PLAN REVIEW SHEET

Petition #: RZP 2022-197

Address: 10130 Mallard Creek Rd.

Request: MUDD-O

RZ-1

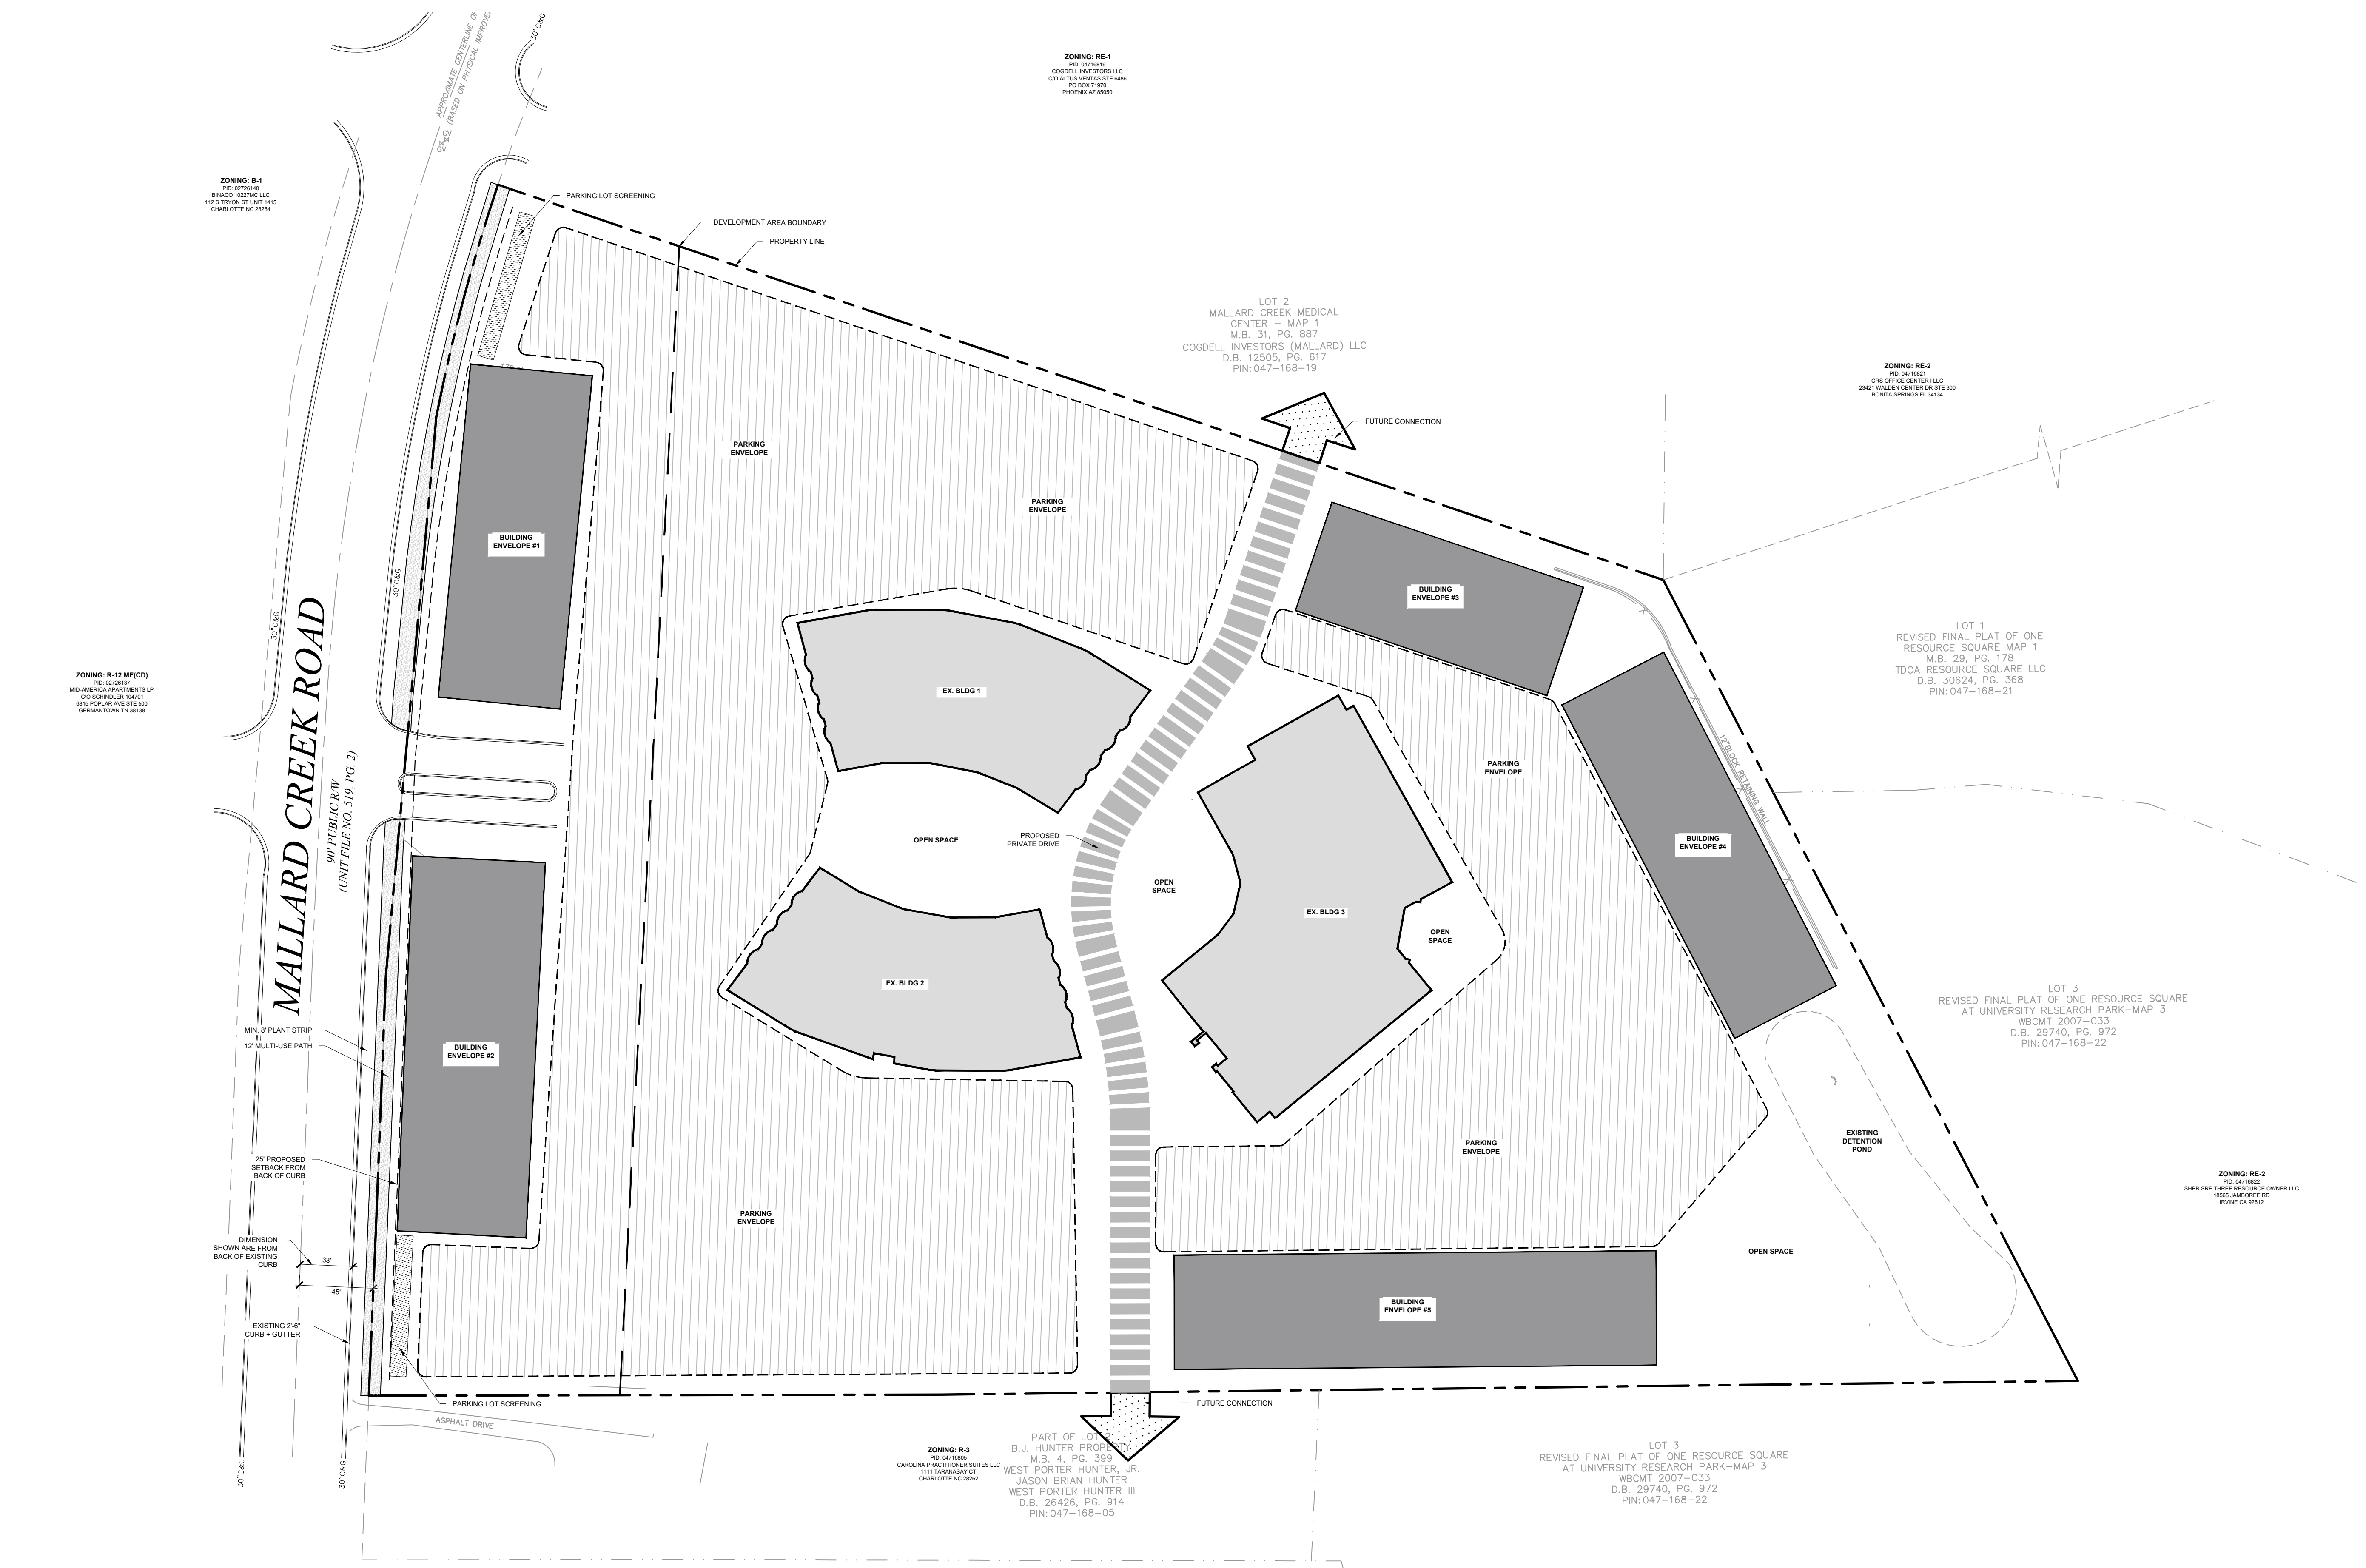
The site is located along CATS local bus route #50 on Mallard Creek Road. CATS requests the construction of ADA compliant bus standard detail 60.02A on Mallard Creek Road. The final location will be coordinated with the developer during the Land Development plan review process.
